CITY OF ALBUQUERQUE

**Re: 900 Griegos Road Townhomes Grading and Drainage Plan
Engineer's Stamp date 03-06-13 (F-14/D067)**

Based upon the information provided in your submittal received 03-06-13, the above referenced Grading and Drainage Plan is approved for Building Permit with the following comments:

900 GRIEGOS ROAD TOWNHOUSE PROJECT	DRAWN BY WCWJ
	GRADING AND DRAINAGE PLAN	DATE 2-04-13
	DAVID SOULE P.E. #14522	21258-LAYOUT-11-13-12
		SHEET # 3 OF 6
		JOB # 21258

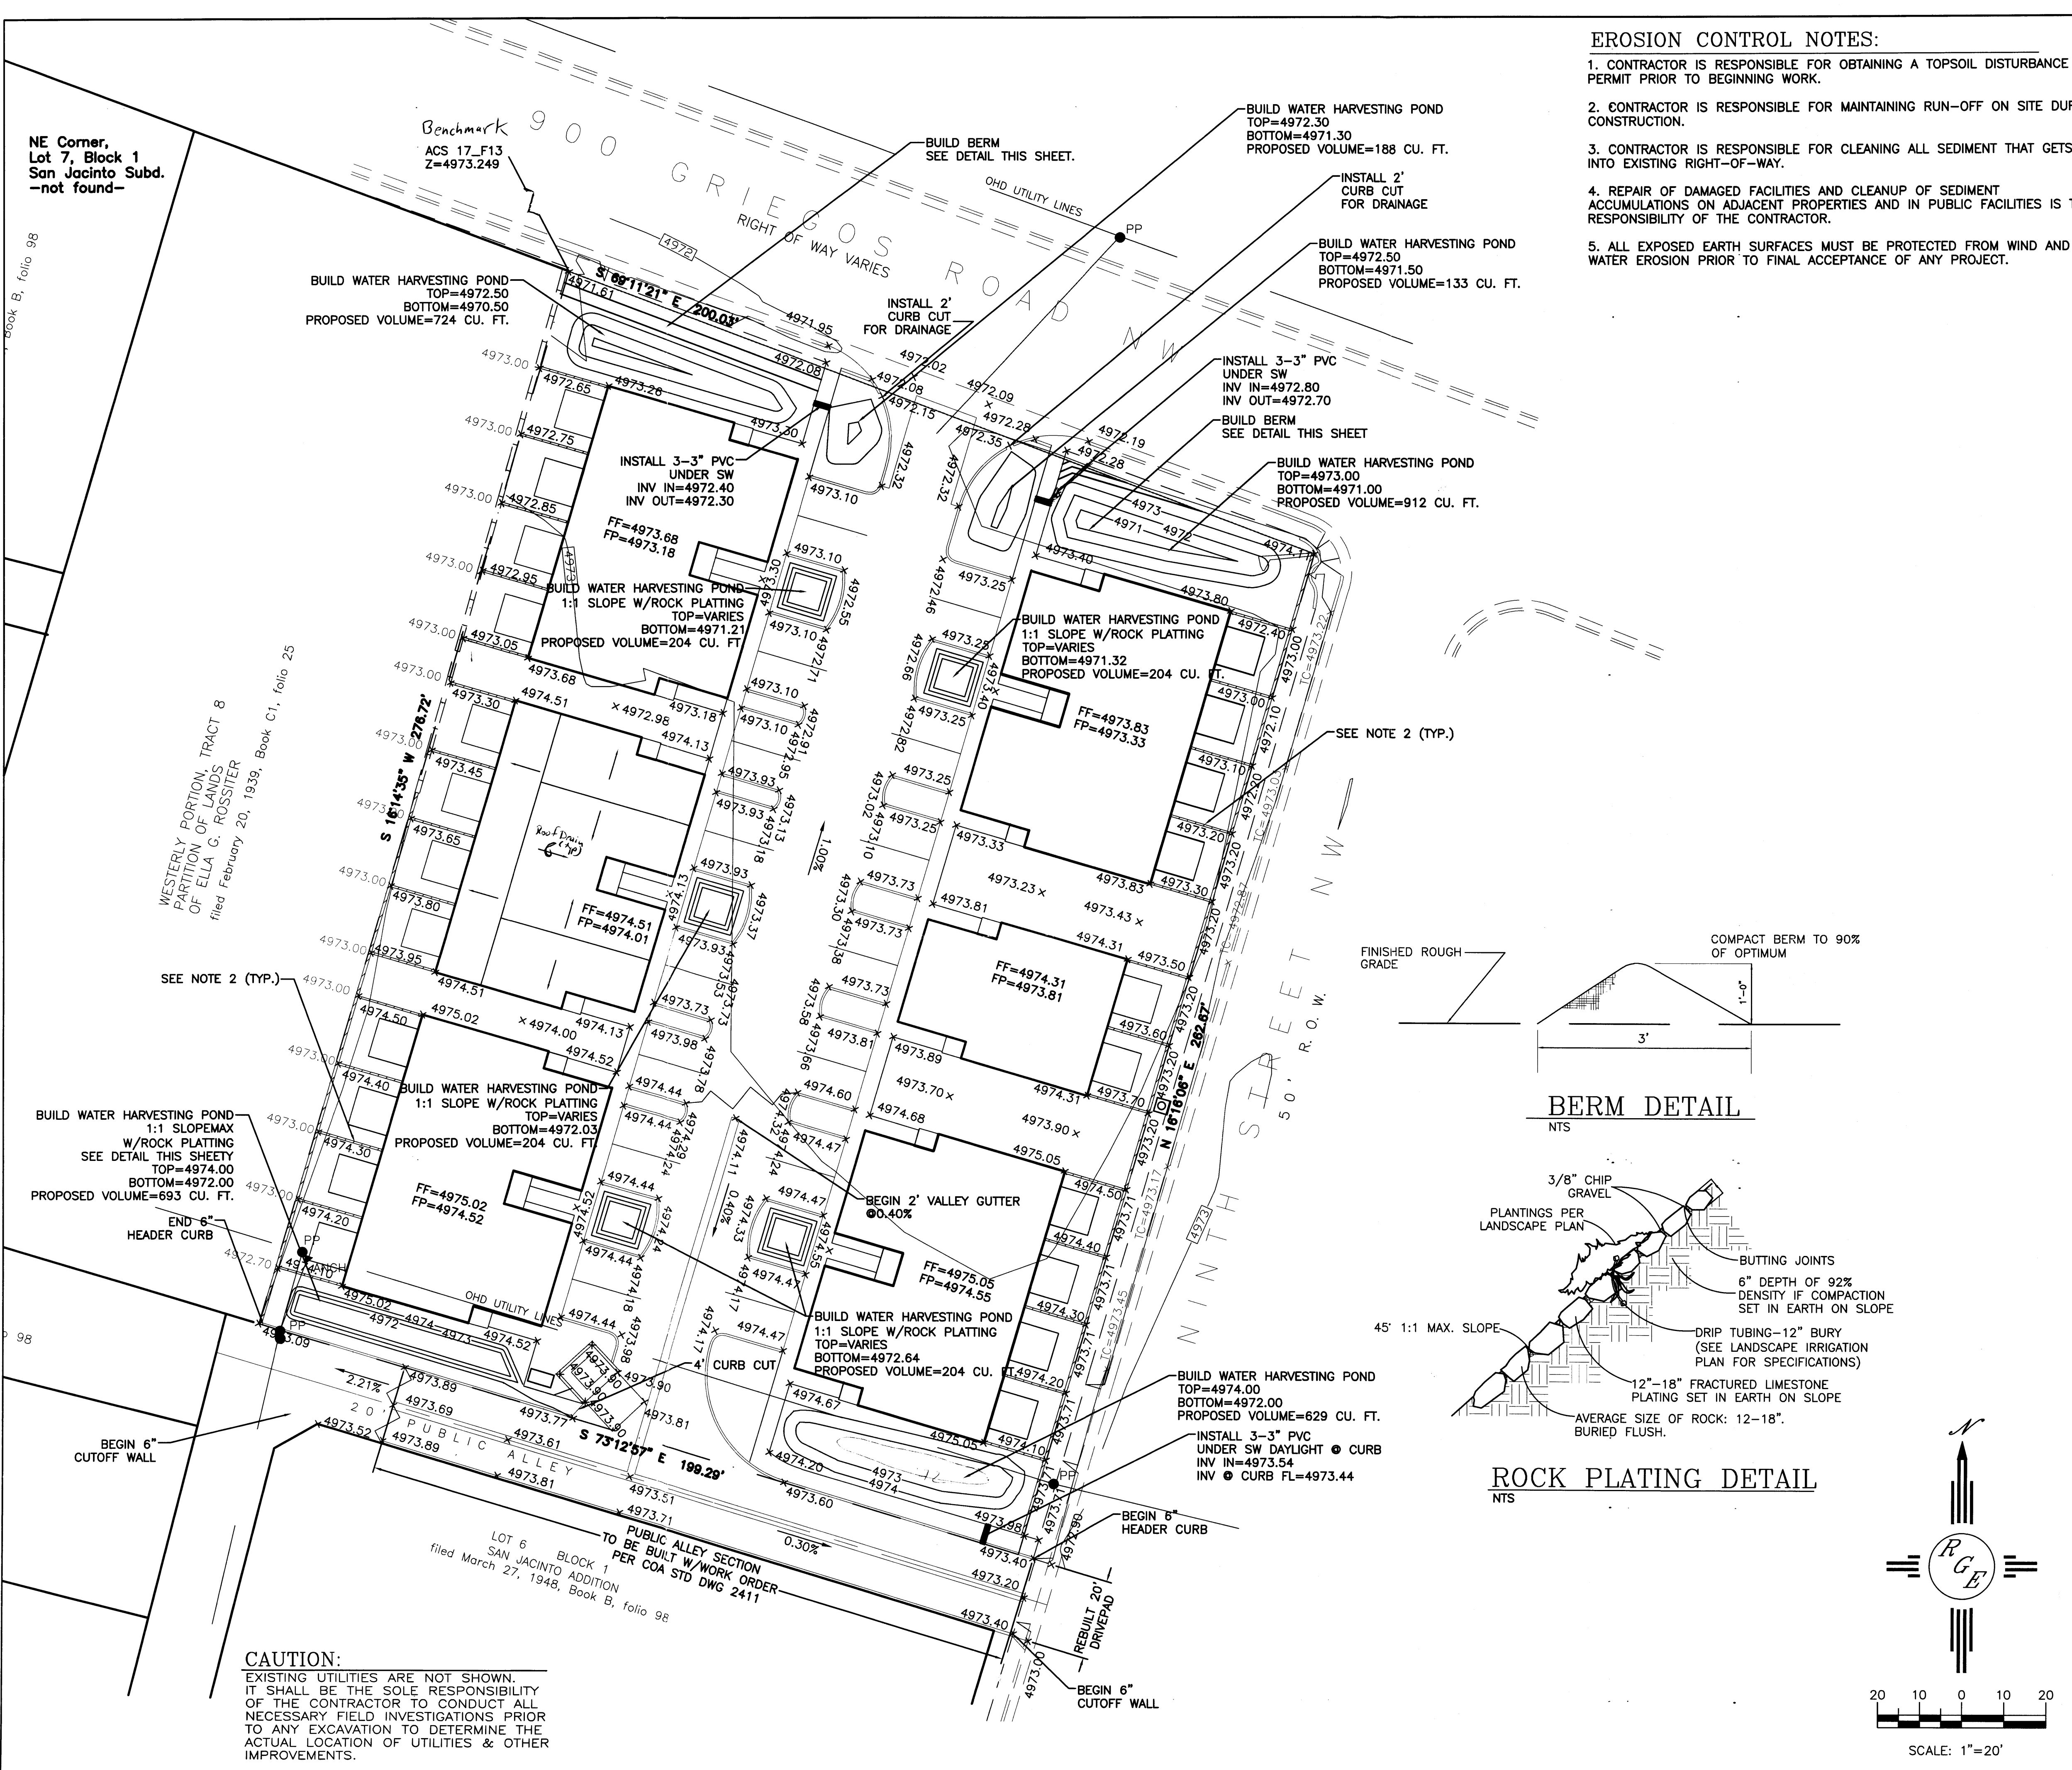
- Please make sure that the as-built elevations clearly will show the bottom elevation (4972.00) for the proposed pond at the southeast corner of the property; this contour is still absent in the revised plan set.
